Re: MMC East Tower and Visitor Garage Conditions of Approval

Below I have summarized the expectations related to the "*Sound Measurement Plan*" referenced in the condition of approval (quoted below).

Figure 1 – Sound Measurement Locations

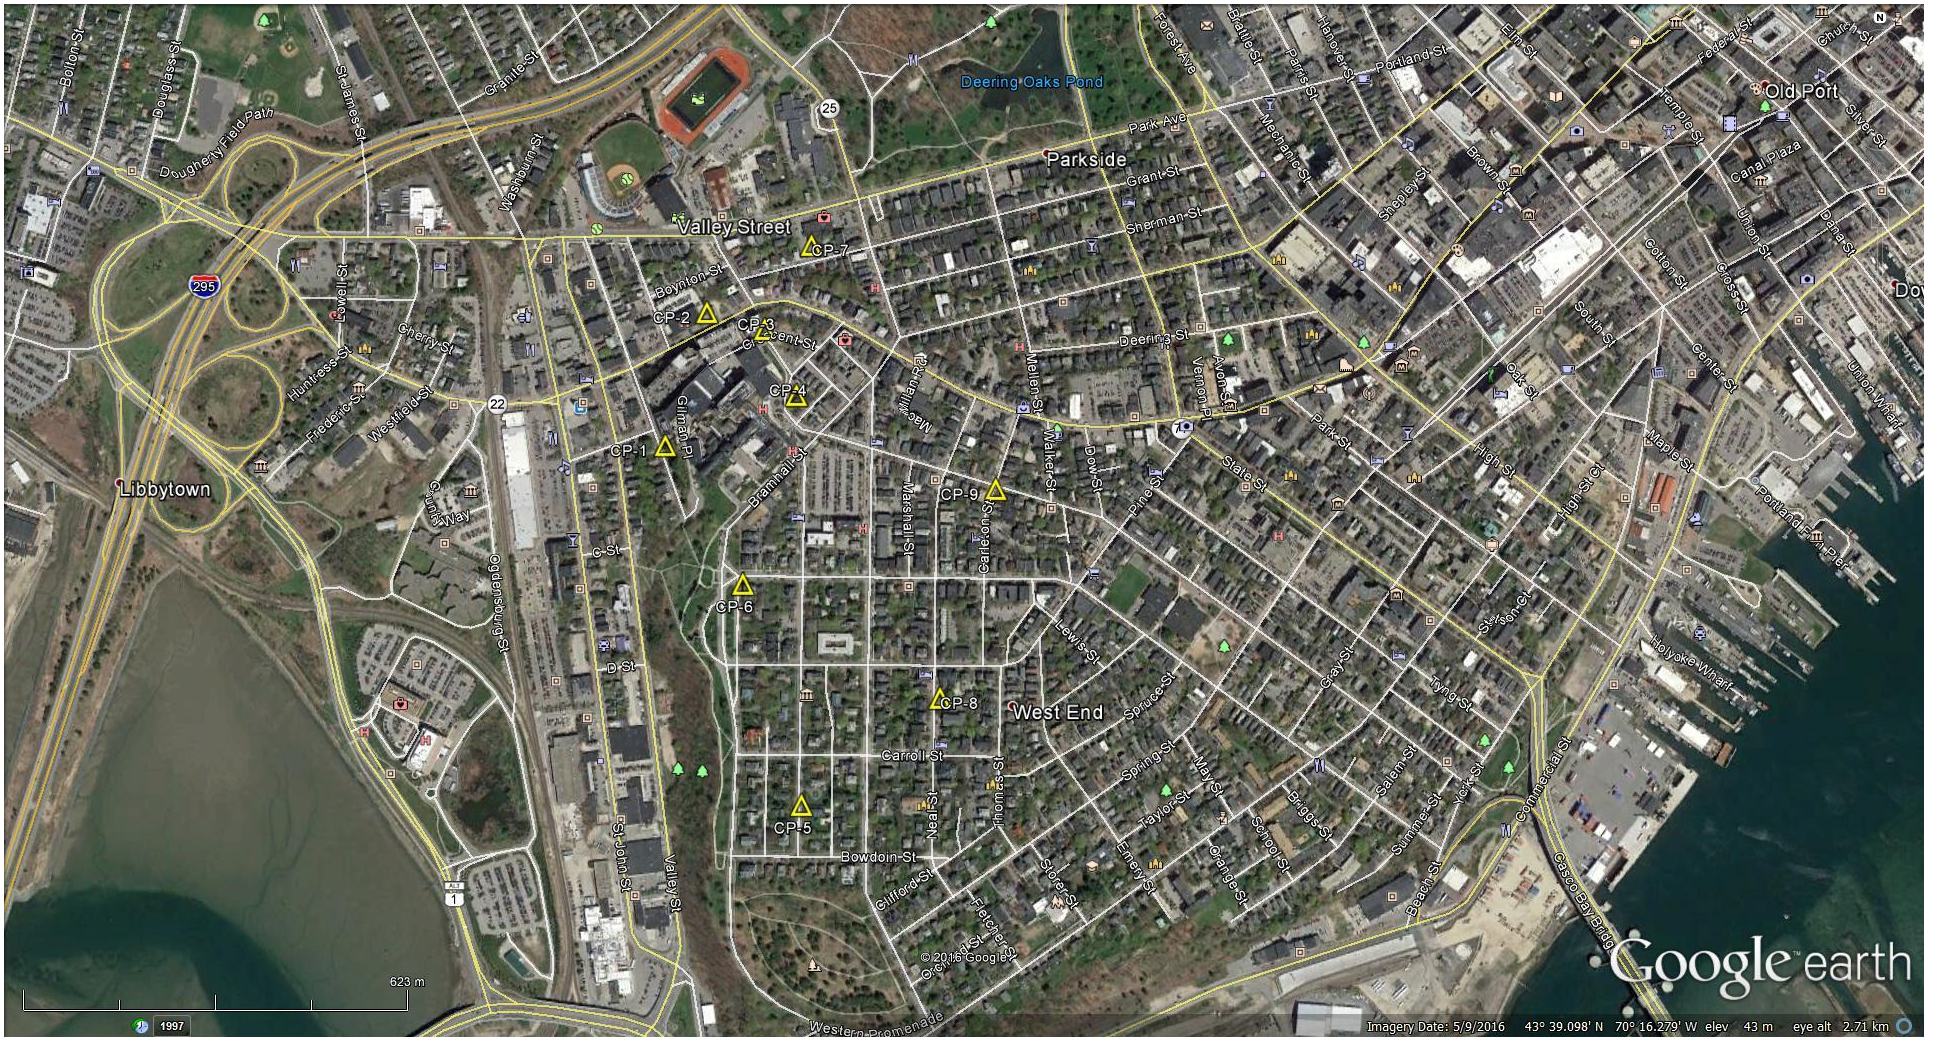
1. The identification of several additional study points to reflect the fact that the new helipad location will not benefit from the shadow of any MMC or other building (documents from the 2005 review confirm that it was assumed by both MMC and City sound consultants that sound from the helipad at its existing location would be "blocked" by buildings to the north of it). The new location could affect residents and businesses that are not impacted by the existing helipad. The plan below (from your submitted report) shows the original study locations for the submitted sound study and there are no points to the mid north and to the NE of the proposed helipad location.
